Planning Application Reference: **CM/34/21/PL**

Site Address: Maidenhead Aquatics, Crookthorn Lane, Climping BN17 5SN

Description of Works: Change of use of part of site to car wash including siting of cabin and canopy. This application may affect the setting of a listed building & is in CIL Zone 5 (Zero Rated) as other development.

I am writing to register my **objection** to the above Planning Application recently submitted by Brightfield Group.

project title
Car Wash at Maidenhead Aquatics Site
Littlehampton
drawing title
Elevations

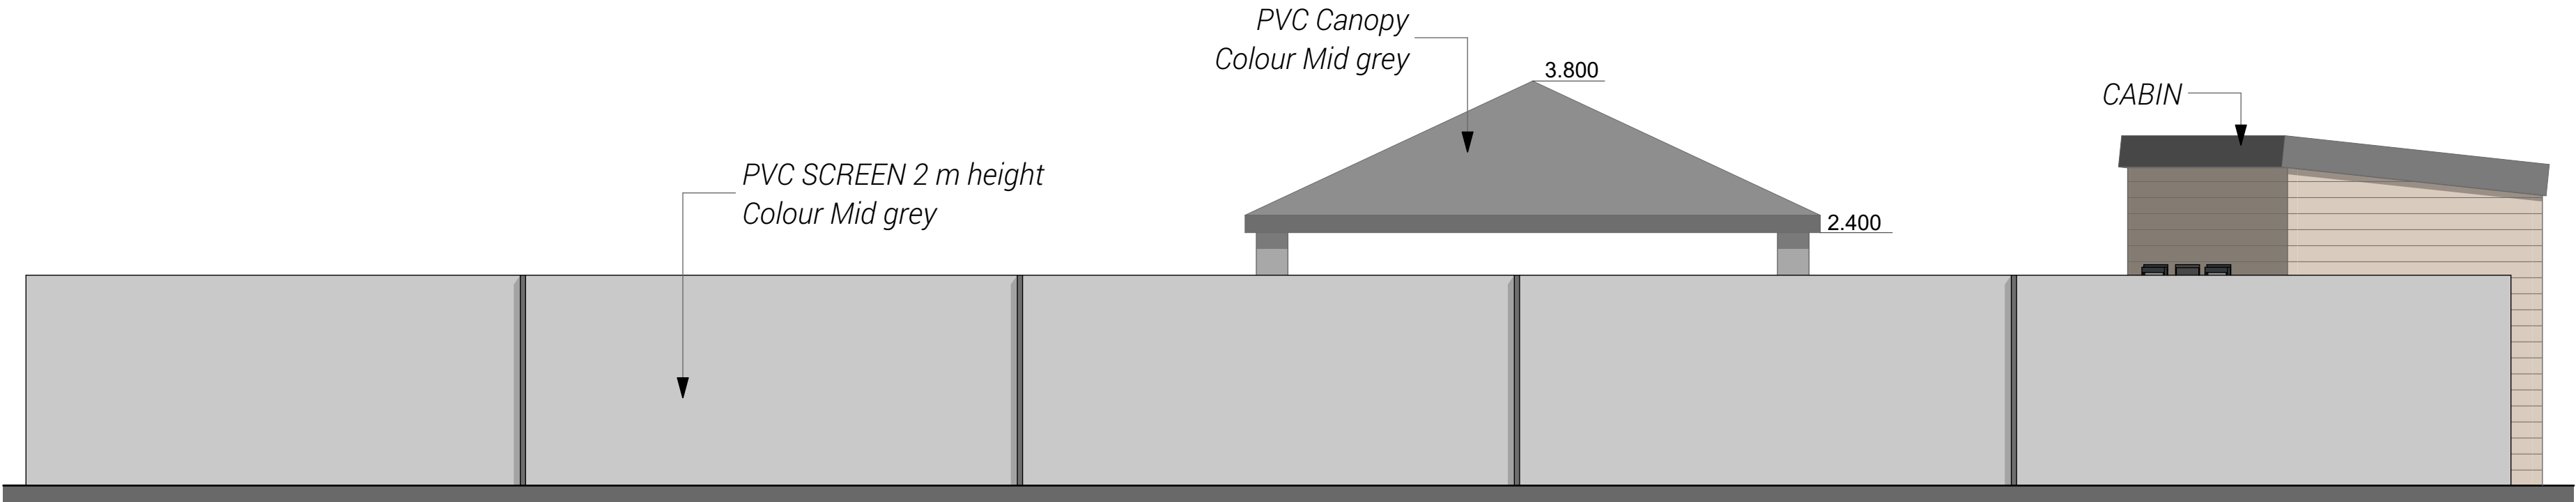
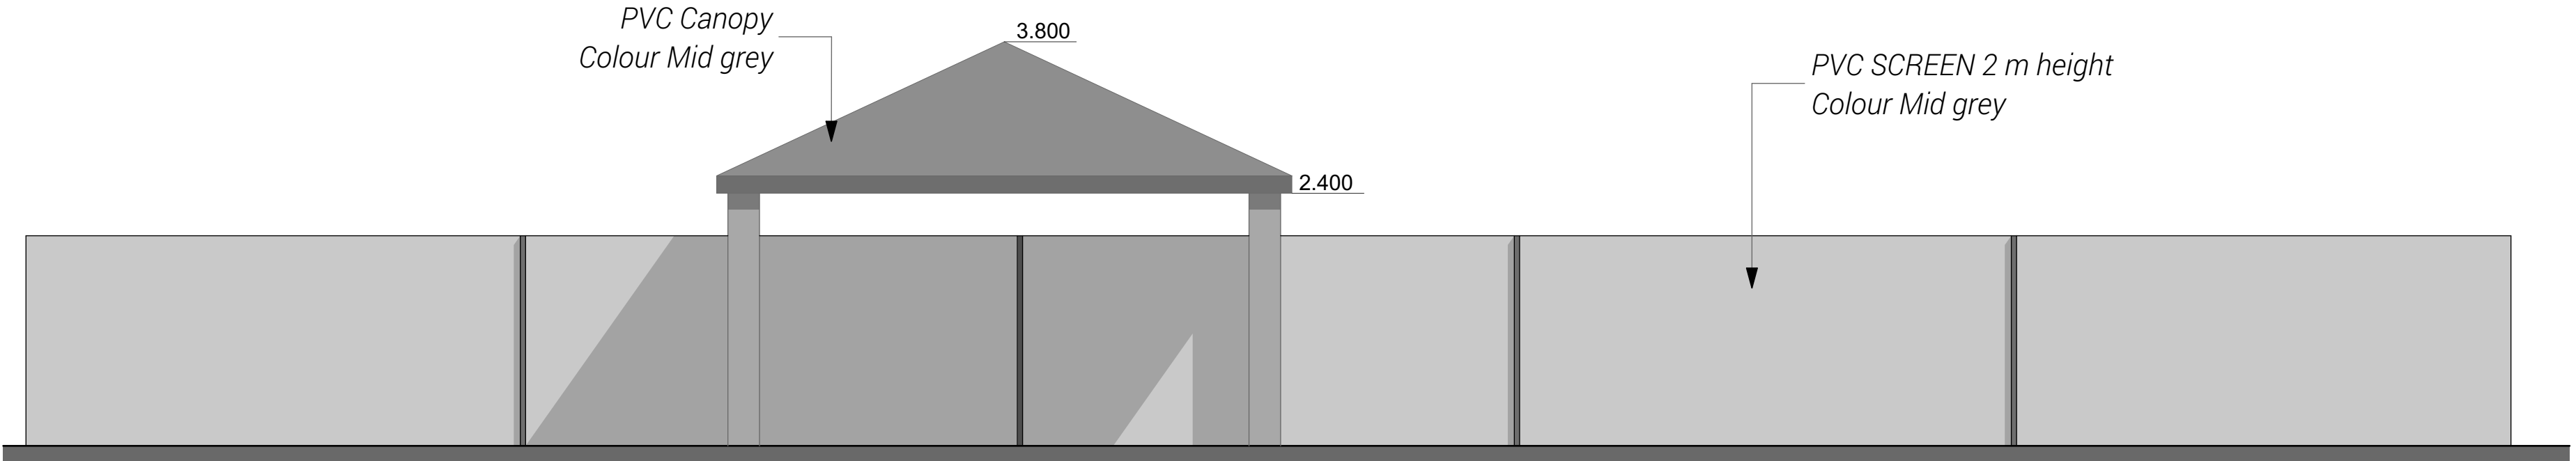
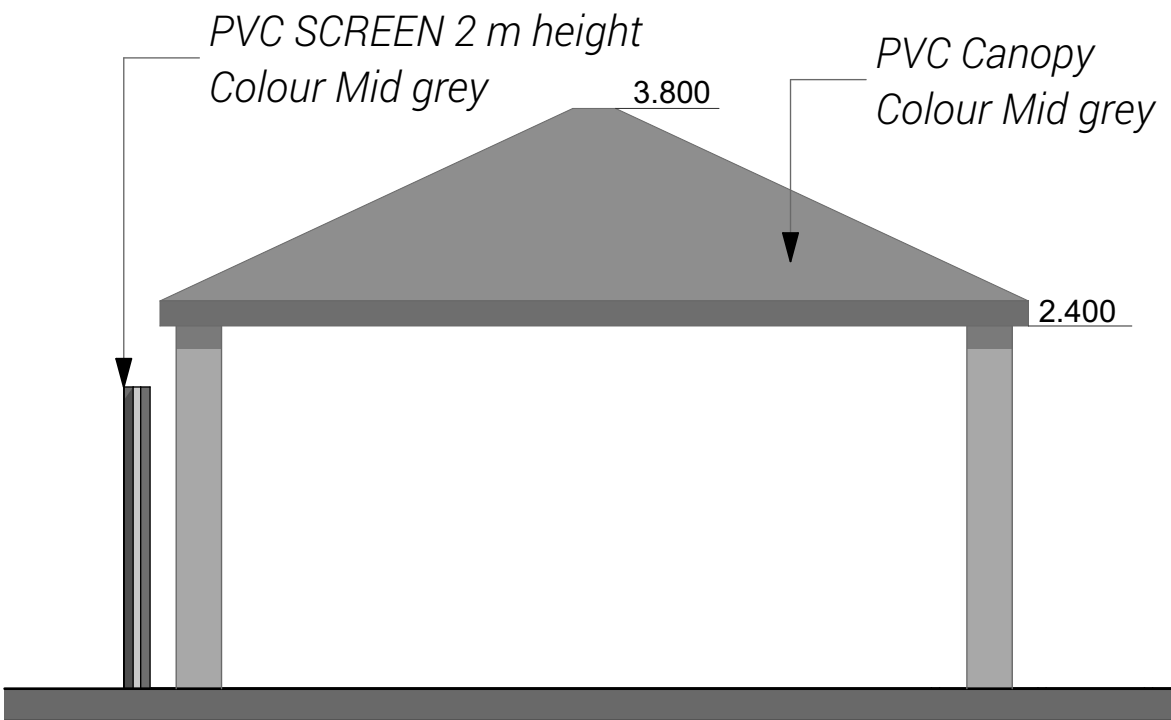
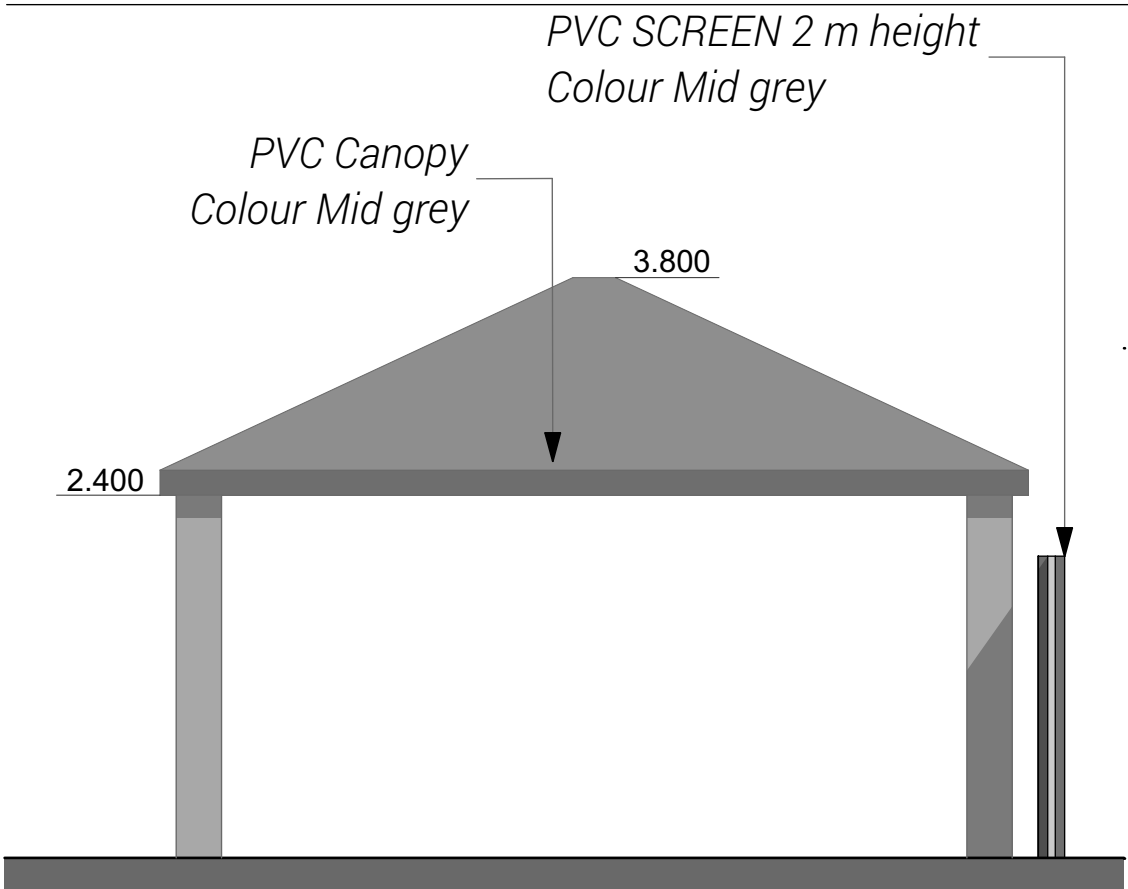
- There are only 3 mature, evergreen trees remaining along this section of boundary, the rest of the boundary planting being a mix of overgrown deciduous bushes, nettles and brambles. When these are not in leaf (6 months of the year), there will be a clear view from the Cottage of the top of the car wash cabin and of the red canopy and its large metal supports, above the height of the proposed 2 metre fence.
